**Submission to the NSW Department of Planning and Environment regarding Modification 9:
MAULES CREEK COAL MINE BIODIVERSITY OFFSET AND ROMA BORE ELECTRICITY TRANSMISSION
LINE MODIFICATION REPORT - MP10_0138-Mod-9**

Maules Creek Coal Mine (MCCM) is seeking approval to modify the NSW Project Approval (PA) 10_0138 to authorise changes to the existing biodiversity offset strategy and the construction and use of a new Roma Bore electrical transmission line.

Figure 2: Vegetation Communities on Northern Offset Properties

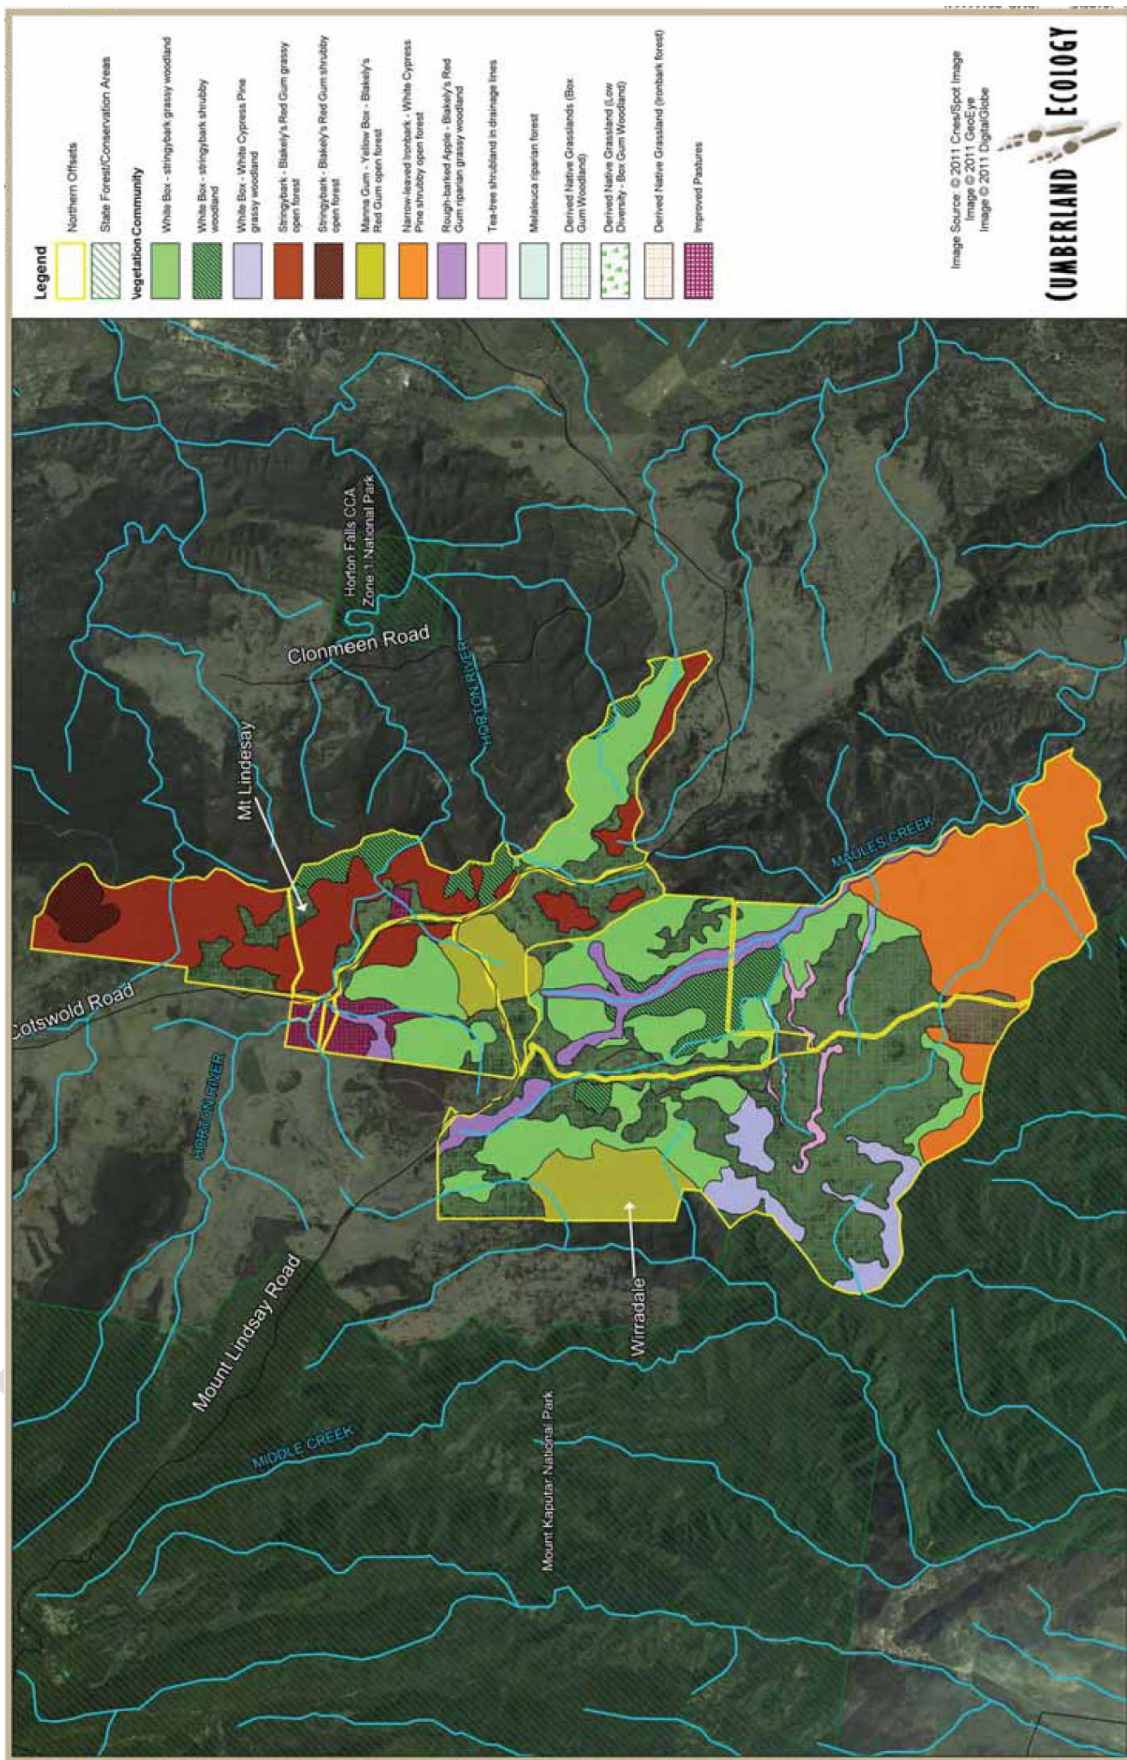
The vegetation mapping for the Northern Offset properties, undertaken initially by Cumberland Ecology (2011) and independently reviewed by Greenloaning Biostudies in 2013 and 2014, identified 4,192.43ha of Box Gum Woodland EEC, that included 1,360.59ha of derived native grassland form. In contrast, the AMBS Modification 9 report identifies a total of only 2,580.8ha of Box Gum Woodland in all forms on the same offset area, that includes 1,190.1ha of derived native grassland. This is a 38% reduction in the total CEEC vegetation area and a 13% reduction in the areas of derived native grassland within the Northern Offsets (refer Table 1).

- How did the original mapping Cumberland Ecology (2011) and the independent review Greenloaning Biostudies (2013 and 2014) get the area of Box Gum Woodland on the Northern Offsets area so wrong? and
- Was this apparent error repeated across other offset areas, mapped by Cumberland Ecology and Greenloaning Biostudies?

The Modification 9 report does not address the obvious inconsistency in areas between AMBS Box Gum Woodland mapping and the Cumberland Ecology/Greenloaning Biostudies CEEC mapping on the Northern or any other approved offset area. Although to the outside observer, it appears likely this discrepancy was the impetus for the purchase of the five additional offset properties supporting Box Gum Woodland vegetation.

The accuracy of the mapping of the EPBC listed Box Gum Woodland CEEC, as presented in the Modification 9 report, is further questionable as a result of the timing of some of the surveys. As an example, AMBS reports the survey of the Northern Offsets was undertaken in May and August 2020, with some additional survey in March 2021. The results of flora surveys in north west NSW (particularly at higher and cooler altitudes as in the Northern Offsets) in these months is somewhat problematic. Autumn and winter are generally outside the active growth, flowering and seed set of many of the ground layer species and within the period of frosts (so become hayed-off) making their detection and identification often difficult. So it is surprising that AMBS identified as many ground layer species on the Northern Offsets as indicated in the report at this time of year.

It is important to note with regard to approval, that it is impossible to verify the accuracy of the PCTs described in the Modification 9 report, including what areas within these PCTs constitute the NSW Box Gum Woodland CEEC versus the Commonwealth Box Gum Woodland CEEC or any TEC for that matter. At very least verification of the areas mapped as this TEC requires interrogation of the plot/transect data collected by AMBS in the field. This is not however provided in the Modification 9 report. Only with plot/transect data can the vegetation mapping and the areas of TECs identified within the report be substantiated.

To avoid the mistakes of the past, perceived or otherwise, an independent verification of the vegetation mapping presented in the Modification 9 report must be carried out by a suitably qualified individual/company familiar the vegetation and landscapes of the NSW northwest slopes and plains and NOT employed or paid directly by MCC. To ensure contractor independence and public faith in the results, MCC should provide funds to NSW DPE or Commonwealth DCCEEW who then directly employ a consultant of their own choosing. By this method many of the obvious pitfalls of pecuniary conflicts of interest would be avoided.
